# CITY OF ALBUQUERQUE

**Re: PurLife  
4320 Lead Ave. SE  
Traffic Circulation Layout  
Architect's Stamp XX-XX-XX (K17-D047)**

Based upon the information provided in your submittal received 01-16-17, the above referenced plan cannot be approved for Building Permit until the following comments are addressed:

1 SITE PLAN  
A-1 SCALE: 1/8" = 1'-0"

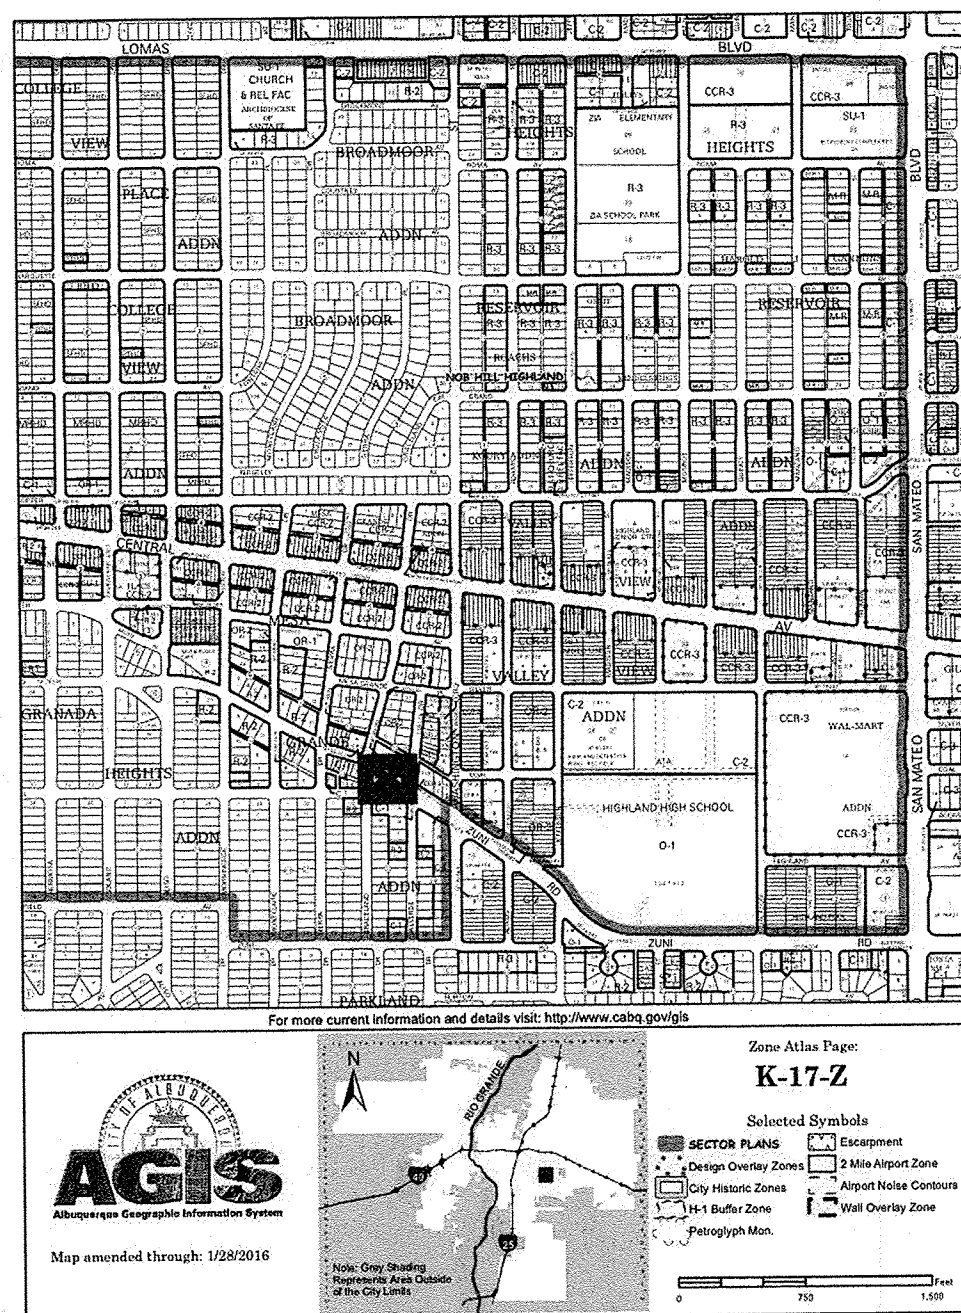
1. The traffic circulation layout must be stamped, signed, and dated by an engineer or architect licensed in the state of New Mexico.
2. Provide a min 6" or max 8" high concrete barrier curb or other acceptable barrier at the top of the current ADA aisle and parking spaces 1 and 2. Please call out detail and location of barrier curb.

3. Please consider moving the ADA parking space to parking space 9 and 10. (we will allow 8 foot wide parking spaces where the current ADA spot is if you are not able to fit a standard spot in its place.)
4. Please make all parking space 18 feet in length. This may help with flow.
5. Are both Motorcycle spaces needed? One can be eliminated to help flow if needed.
